Response to Planning Application Further consultation comments 19/08/21

Application ref: A/26/21/RES

Description: Approval of reserved matters following outline consent A/44/17/OUT for appearance, landscaping, layout & scale for the demolition of existing buildings on site & erection of a mixed use development comprising of 90 No. residential dwellings & a care home & ancillary facilities including railway crossing together with associated access, car parking & landscaping. This application also lies within the parishes of Rustington & Littlehampton.

Location: Land west of Brook Lane and South of A259 Angmering BN16 3JL

Play Areas

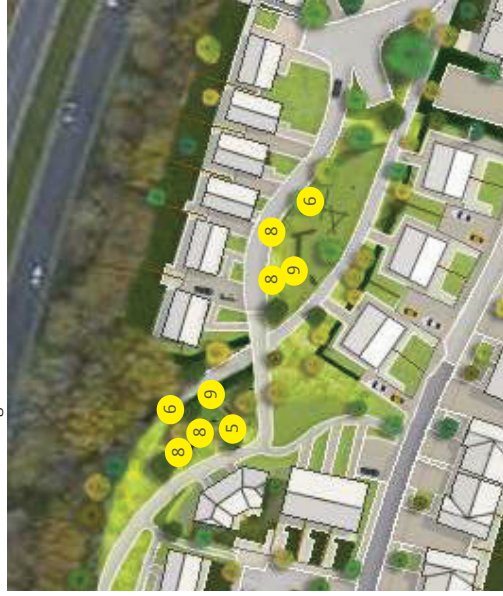
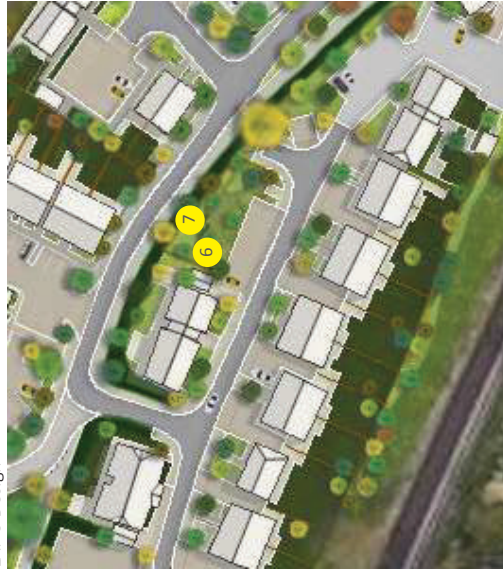
- Landscape Plan 176-003 Rev P3 has detail of LEAP however this information is not sufficient in detail and needs to be provided in separate plan form detailing equipment choice, fencing and surfacing proposed. This information needs to be consistent with that shown in the revised DAS. Play equipment for a LEAP catering for 90no dwellings needs to provide for a good variety of play experience, be accessible and inclusive, providing also seating and bins and fencing as appropriate. This applies also to the 3no LAPs which are shown within the scheme.
